Submission for Job: #6011 SSD 6011 - Mixed use residential development within the South West Plot
https://majorprojects.affinitylive.com/?action=view_job&id=6011

SSD 6011 - Mixed use residential development within the South West Plot

23 July 2013

Winter Solstice 9am

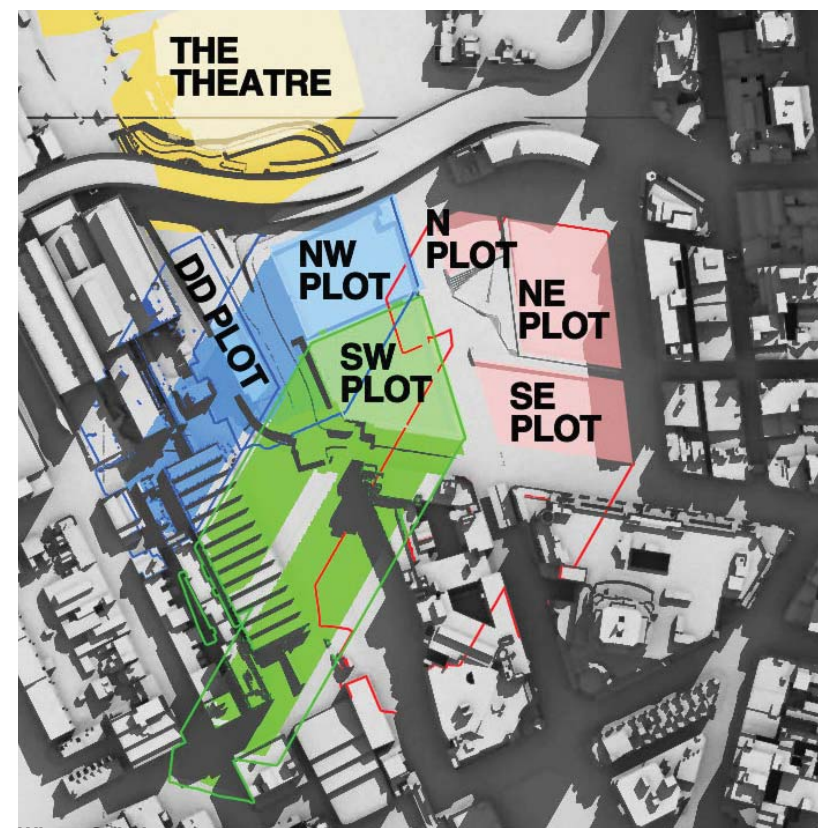
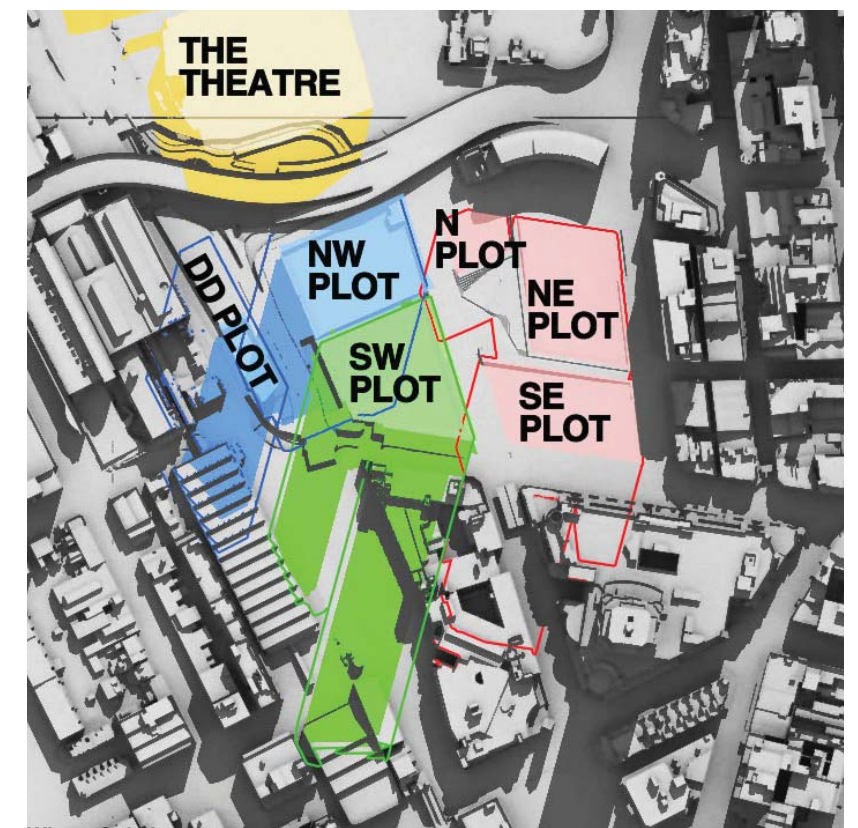
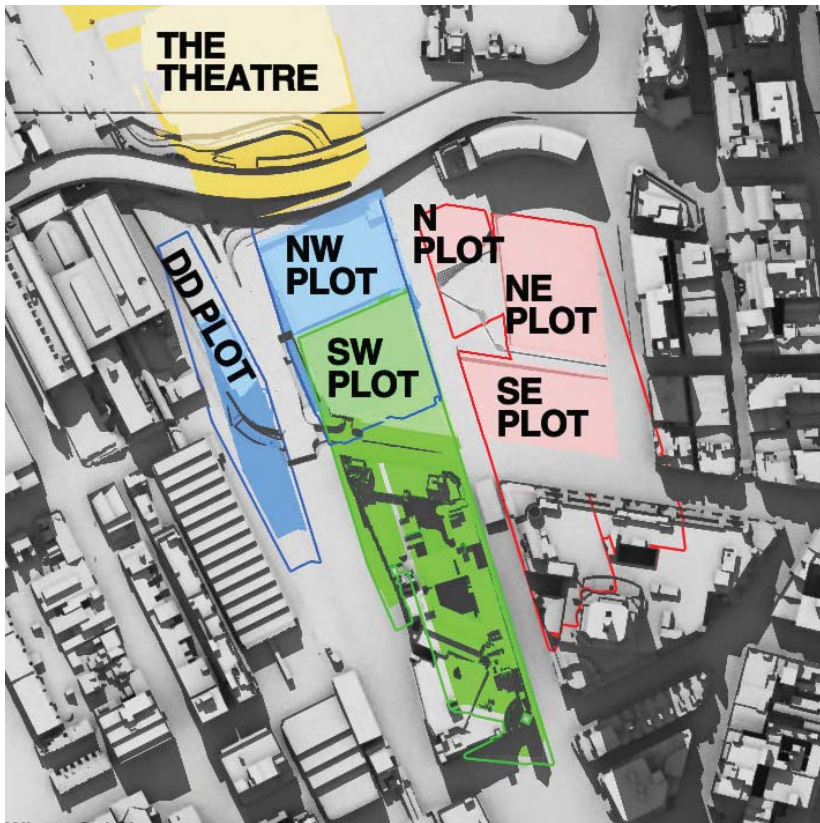
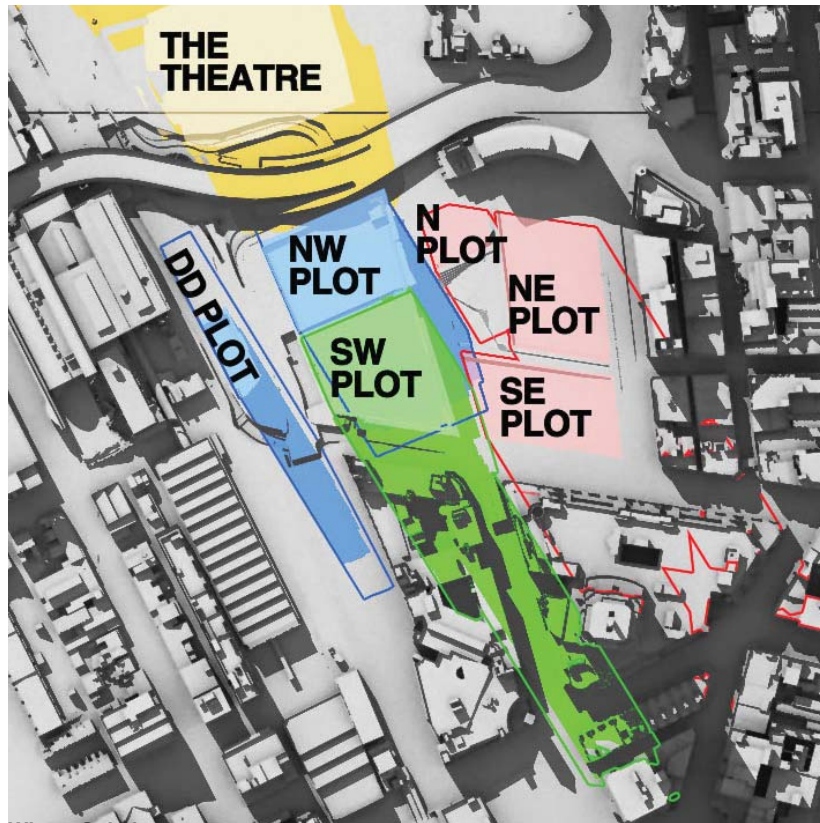
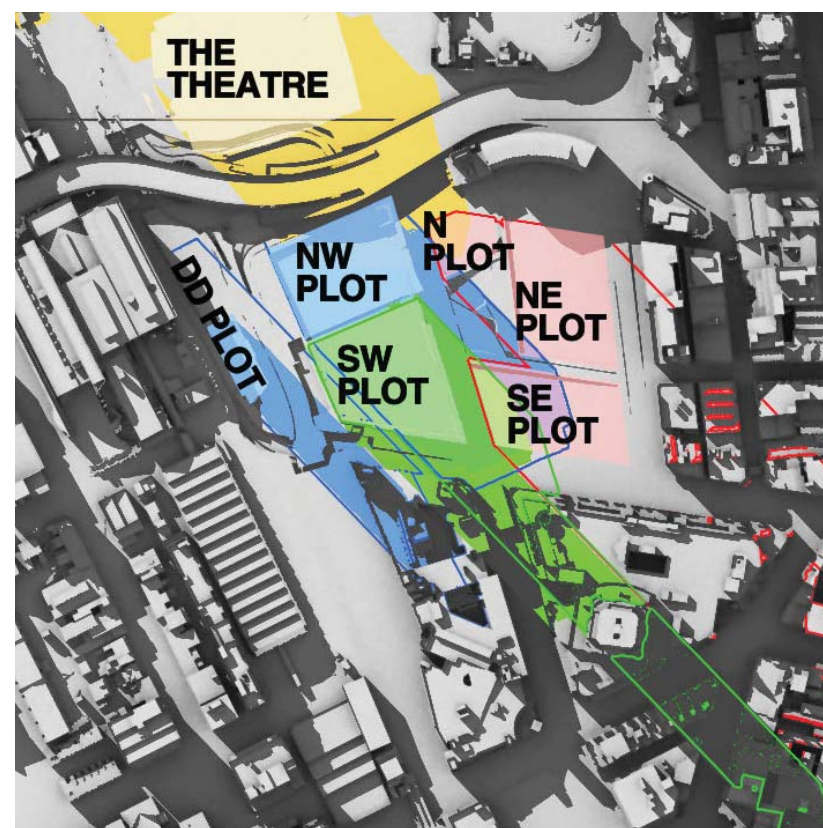
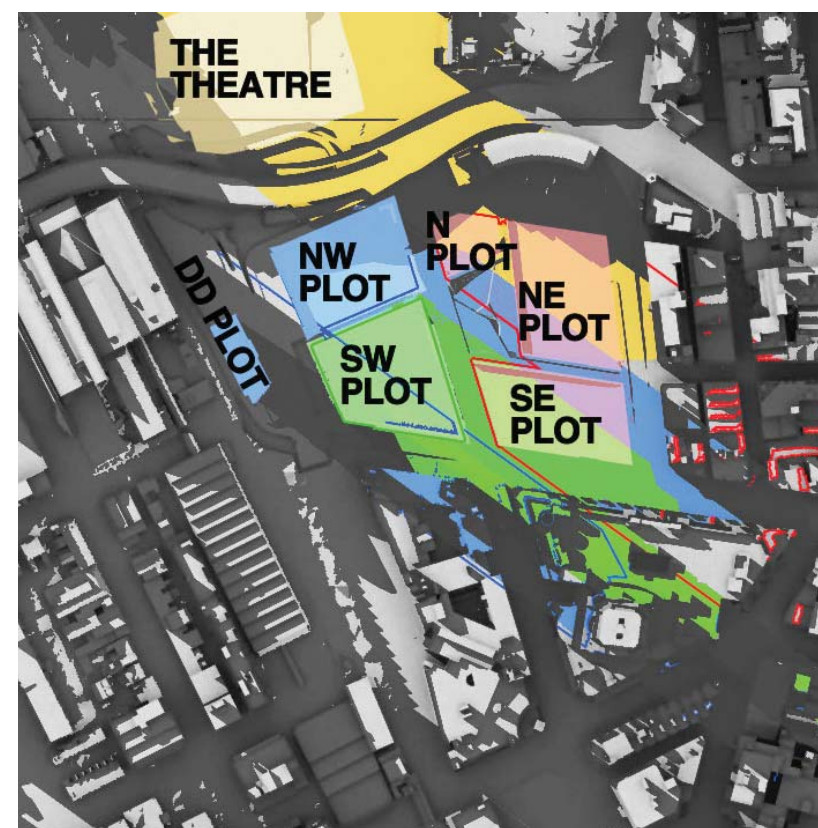
At 9am, 10am and 11am the west façade is totally in shadow due to other parts of The Peak building itself.

At 12pm there is still substantial existing shadowing on the west façade caused by the irregular shape of the west facade.

At 1pm the existing shadowing has been substantially removed, but not totally removed.

It can be concluded that some single aspect apartments on the west façade and some south-west dual aspect corner apartments currently receive less than 2 hours direct sunlight to habitable rooms and 50% of the private open space between 9am and 3pm on 21 June.

By 2pm the existing shadowing has been totally removed, but that is too late to achieve two hours of direct sunlight before 3pm.

At 9am, 10am and 11am the west façade is totally in shadow due to other parts of The Peak building itself.

At 12pm there is still substantial existing shadowing on the west façade caused by the irregular shape of the west facade.

At 1pm the existing shadowing has been substantially, although not entirely, removed. However, overshadowing of lower levels of the west façade by the concept proposal parameter plan shadows for the N,NE and SE plots has already started.

By 2pm the existing shadowing has been totally removed. However, overshadowing of the west façade by the SSDA4 and SSDA5 buildings has appeared and risen further up the west façade than the concept proposal parameter plan shadows for the N,NE and SE plots, which is still present.

At 3pm, the proponent states correctly that 45-45% of the western façade is overshadowed by the SSDA4 and SSDA5 buildings.

It can be concluded that, as a result of combination of the proposed development with existing shadowing of the west façade, some single aspect apartments on the west façade and the south-west dual aspect corner apartments which currently receive less than 2 hours direct sunlight to habitable rooms and 50% of the private open space between 9am and 3pm on 21 June will suffer additional overshadowing. It is beyond our skills to count the number of such apartments. We note that the proponent has made no attempt to do so.

Rather than counting the number of units which will not meet the DCP guidelines, the proponent attempts to trade-off direct sunlight at 4pm for lack of direct sunlight during the period 9am to 3pm. There is no provision in the DCP guidelines for such a trade-off.
